Historic England

Our ref: PL00731922

FORD MASTERPLAN CONSULTATION
Application No. F/4/20/OUT

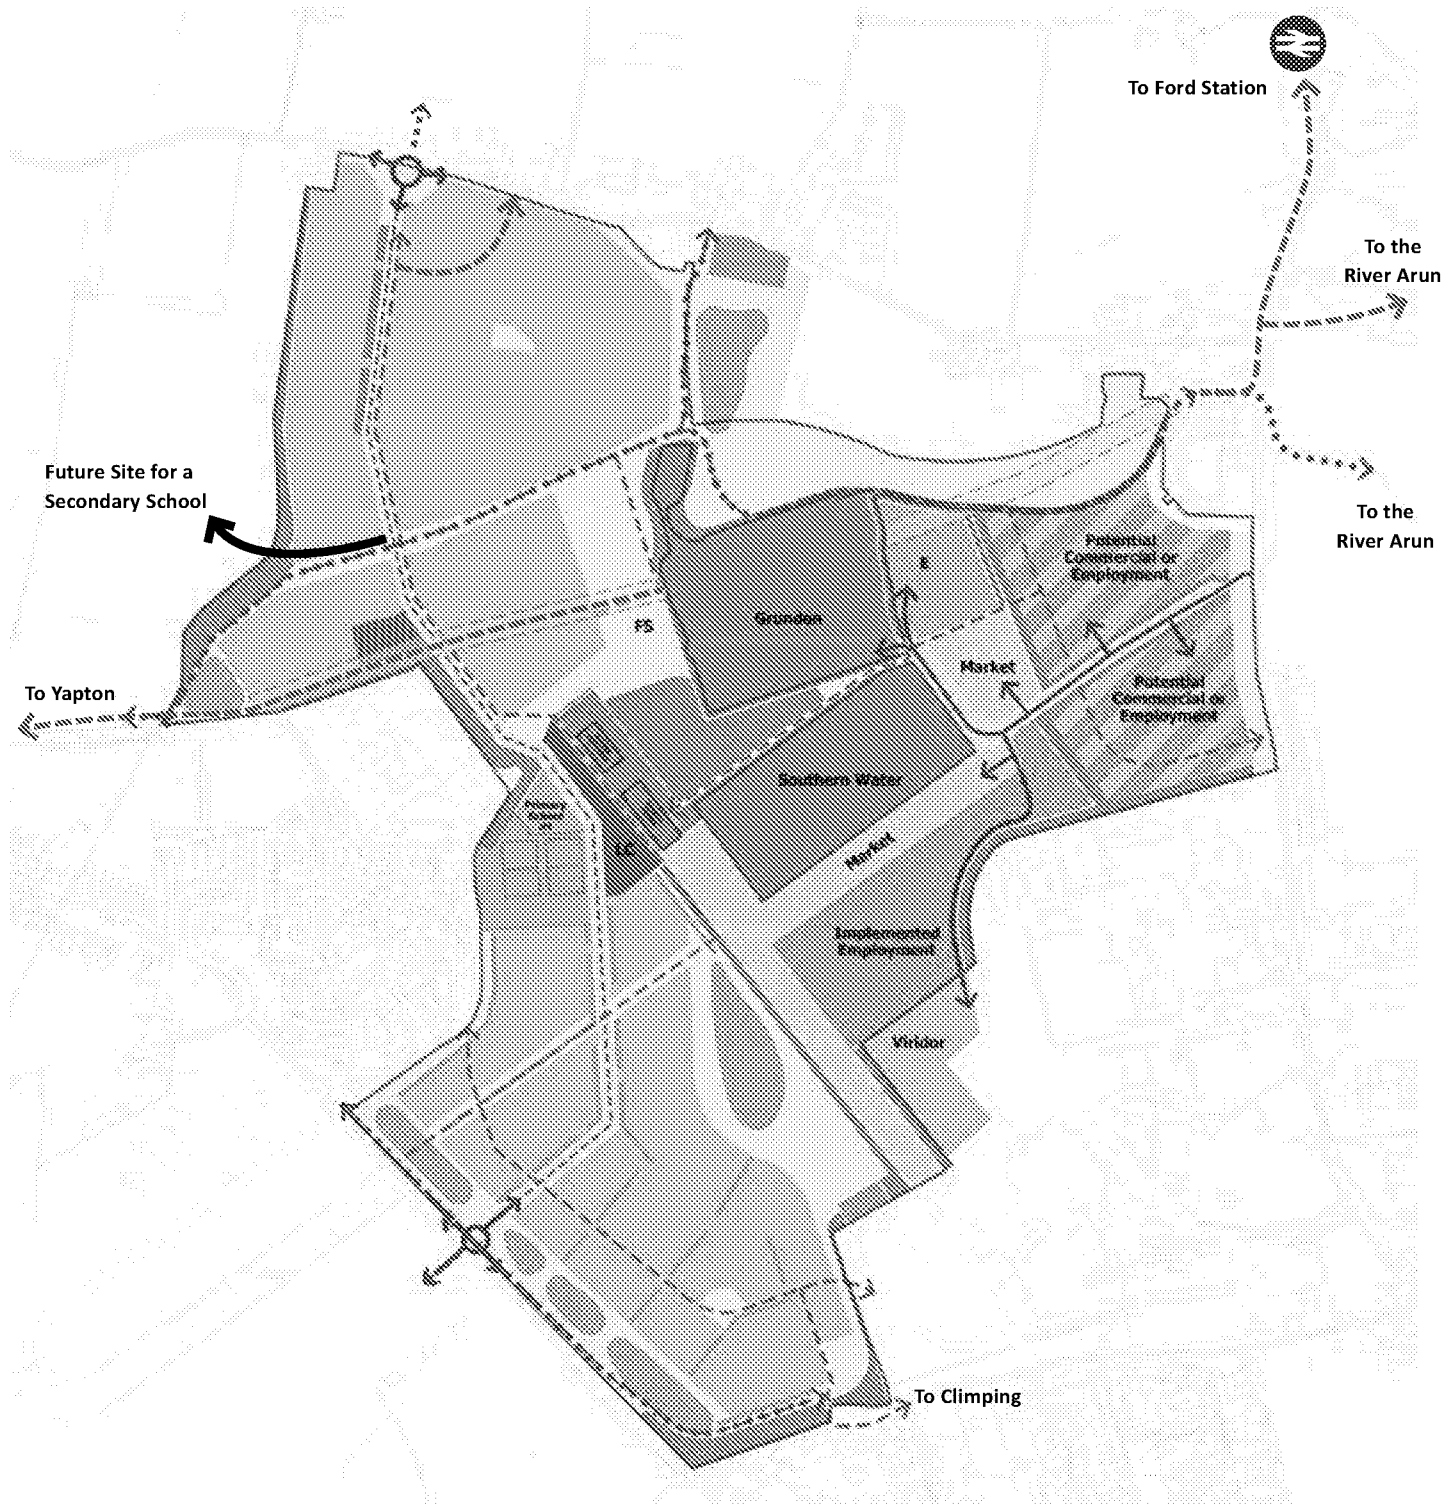
Complete removal of the western arm of the runway would result in the loss of its cruciform shape, which is integral to the unusual character and significance of the airfield. The line of the runway on the western side would be retained as open space, but this would not mitigate its loss, physically or as a key element of the character and appearance of the airfield. While the loss of some of the extreme ends of the runway might be borne without a high degree of loss of significance, complete loss of one arm

We welcome the Masterplan's incorporation of the former route of the Portsmouth to Arundel canal into the open space of the northern area of the proposed development site. This presents opportunities to provide interpretation to commemorate its place in the landscape and increase public knowledge of its role in the evolution of the site, which should be developed as part of future applications.

We are pleased to see that the Masterplan retains the central section of the runways' cruciform shape, although loss of the western arm is unduly harmful to its character. Its reuse as a green space, called "Runway Park" would be a partial mitigation of that loss, but it would be more in line with planning policy to avoid its loss altogether by retaining at least some of the existing runway surface on all four sides and making better use of the centre of the cross as a focal point of the development. There should also be a very clear connection retained, and enhanced by interpretive materials, between the centre of the runways and the memorial adjacent to the western runway arm.

The Masterplan appears to retain the sightlines along the runways. This is a welcome design feature as it would permit visitors to experience the character and some of the scale of the former airfield landscape. Care must be taken during detailed design that tree planting, signage and similar factors do not hinder this retention of this significant part of the airfield's setting and views.
